LSC Responses to TIS Redline Comments

Waterbury Filing Nos. 1 and 2 Traffic Impact Analysis (LSC #204220) March 11, 2022

Figure 1 Conceptual 120' ICD Roundabout Parameters

Waterbury Roundabout (LSC #204220)

WATERBURY FILING NO. 1 & 2
CONSTRUCTION SET
ROUNDABOUT FASTEST PATH

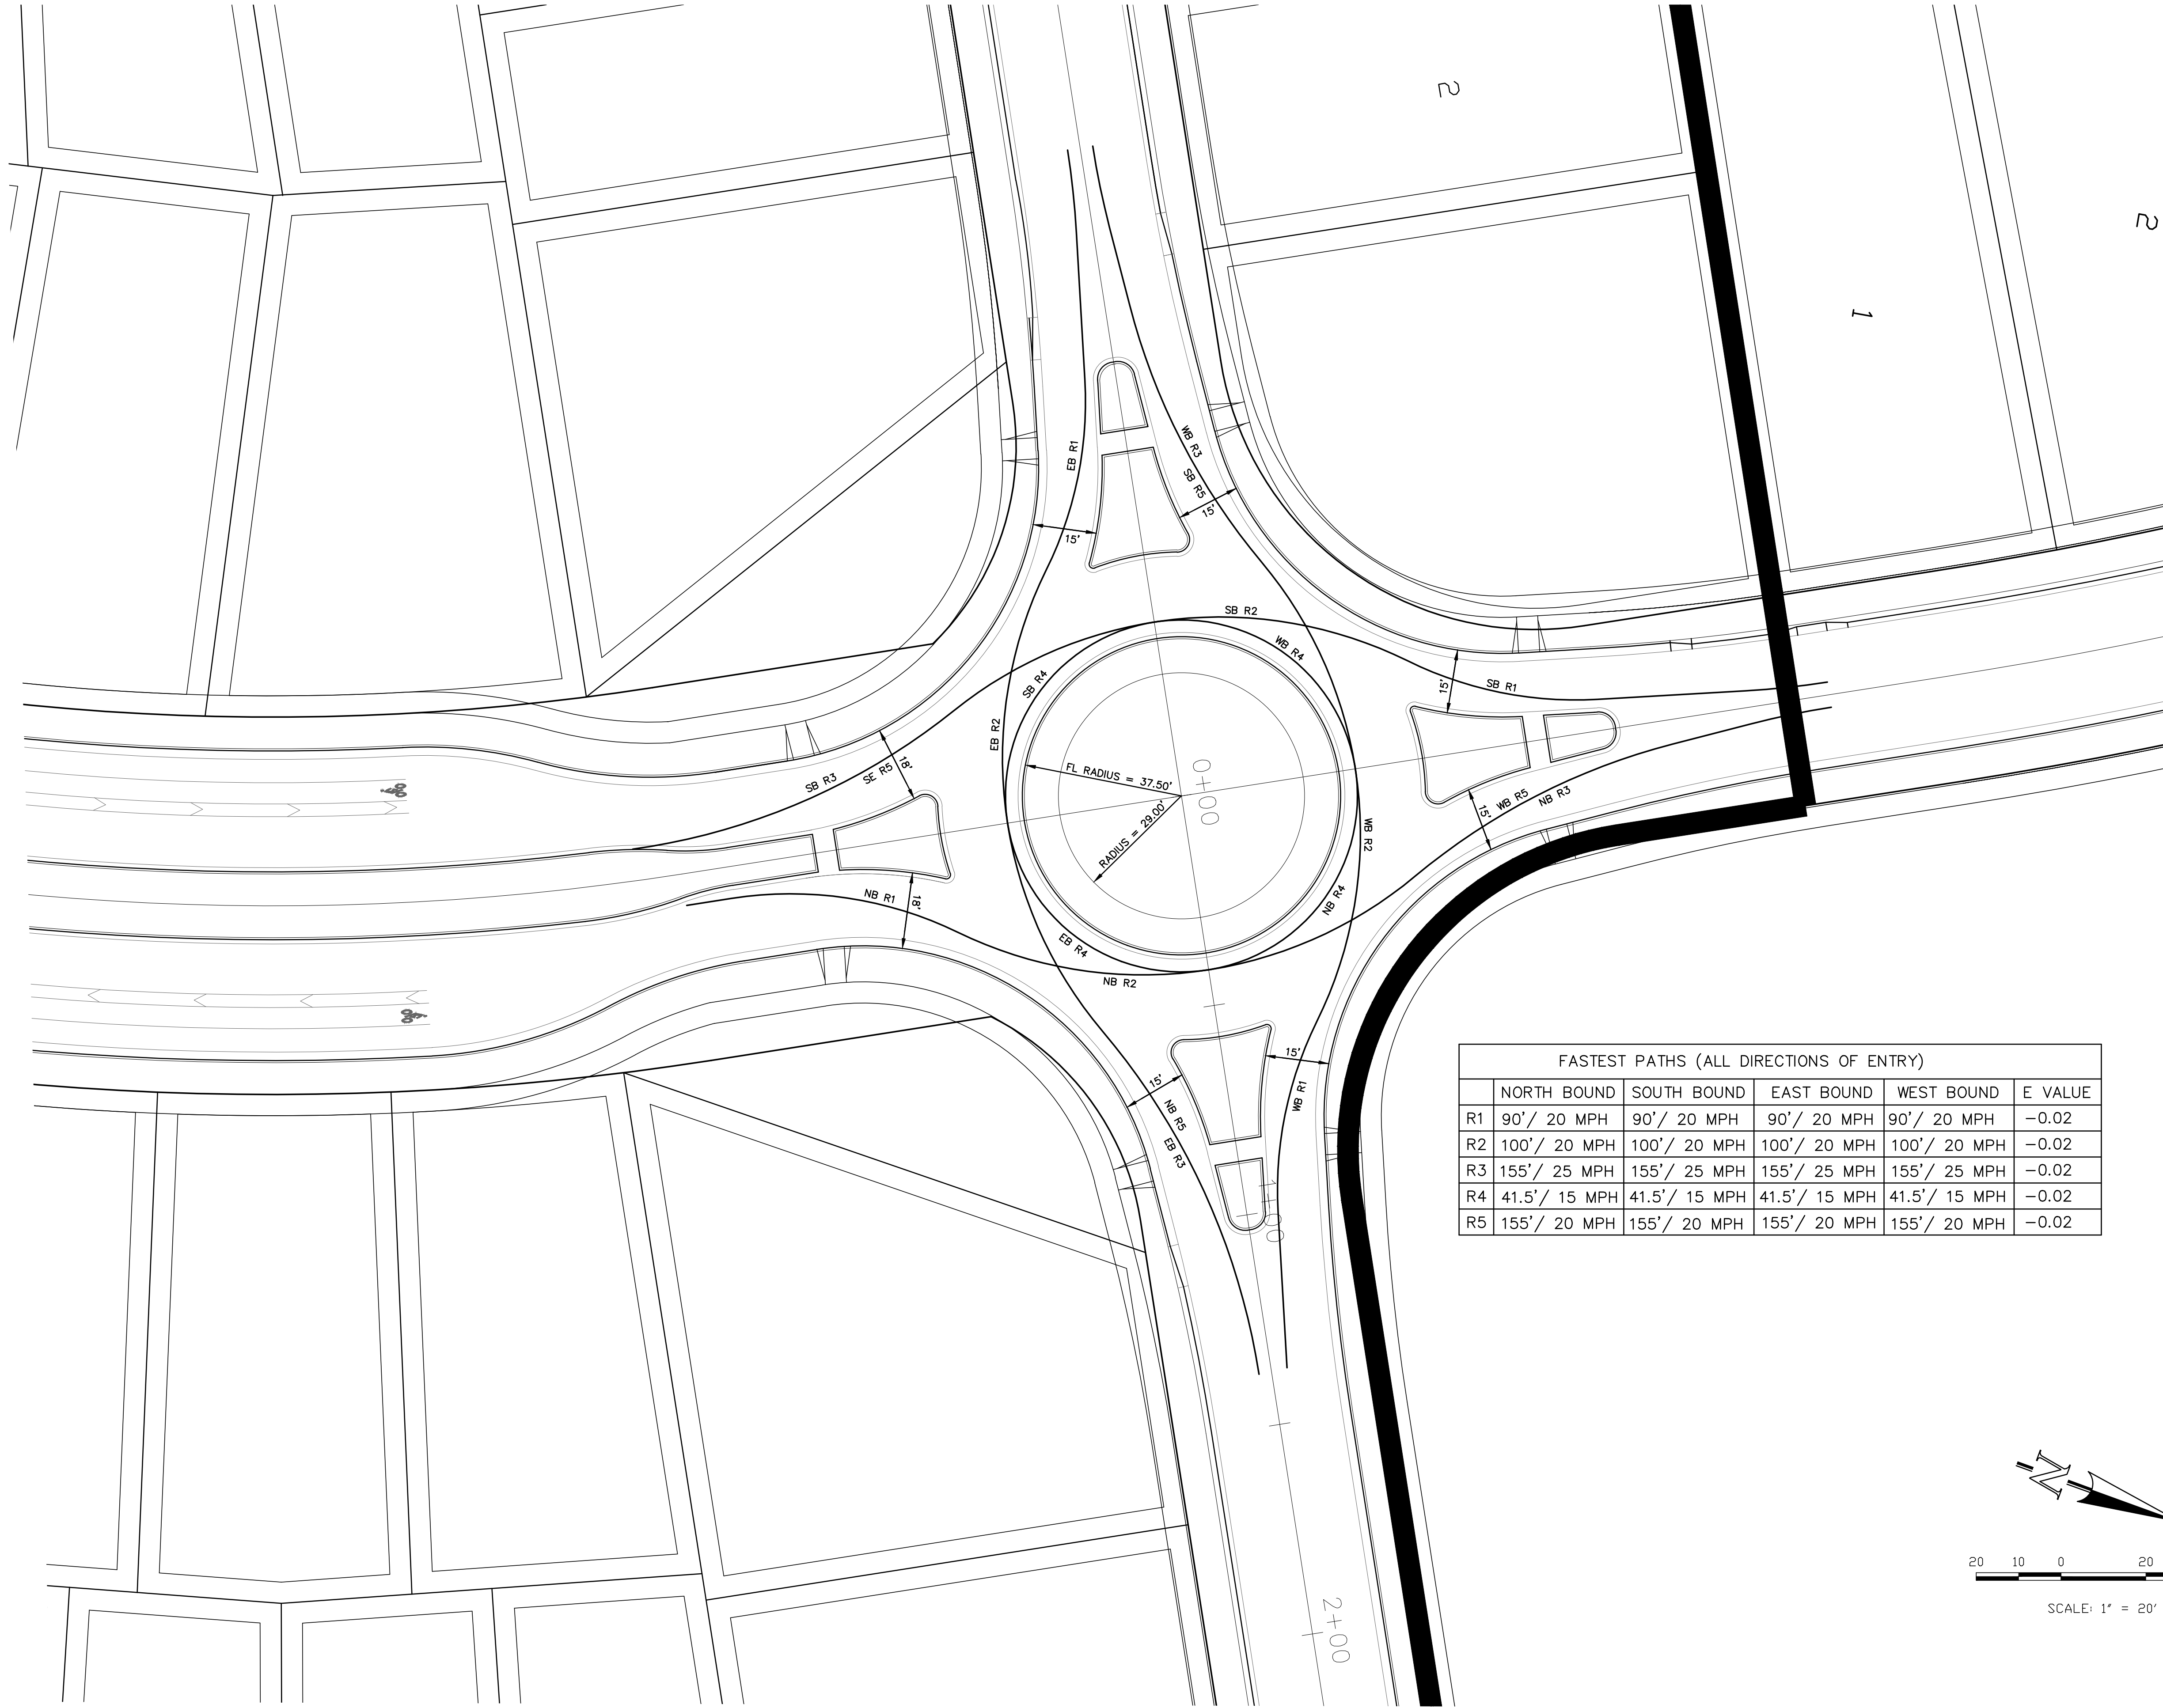
If need to accomodate deisgn vehicle WB-67, as shown on approaches 1 & 3, entry width should be 19-22'.

Truck apron width is usually 15'-20'.

If need to accomodate deisgn vehicle WB-67, as shown on approaches 1 & 3, min inscribed diameter used should be 130'.

Desirable circulatory width is 20'

LSC Response: Per the 6/23 meeting with staff, LSC has added the flowline dimensions in addition to the 16.0' dimensions to reflect use of the hatched area by trucks. As shown, these added dimensions are consistent with the 19-22' shown in the comment.

LSC Response: As discussed, the 15'-20' is acceptable provided the remaining center island can be landscaped sufficiently to limit lines of sight across/through the roundabout. The large apron is primarily needed to accommodate a WB-67 U-turn. A U-turn by a WB-67 is very unlikely; however, as shown in the truck-turning figures, a 270-degree turn is shown for a WB-67 instead of a direct right-turning movement. The larger truck apron is needed for a 270-degree "right-turn" movement.

LSC Response: At the 6/23 meeting with staff, we discussed that the more compact 120' diameter has been used to allow for a roundabout without major impacts to the street/lot layout. The WB-67 truck-turning exhibits show the accommodation of the occasional WB-67 truck, including the larger truck apron as discussed in the above comment response.

LSC Response: Discussed the need for a more compact design. LSC will add the flowline dimension to the splitter island in addition to the 18' dimension.
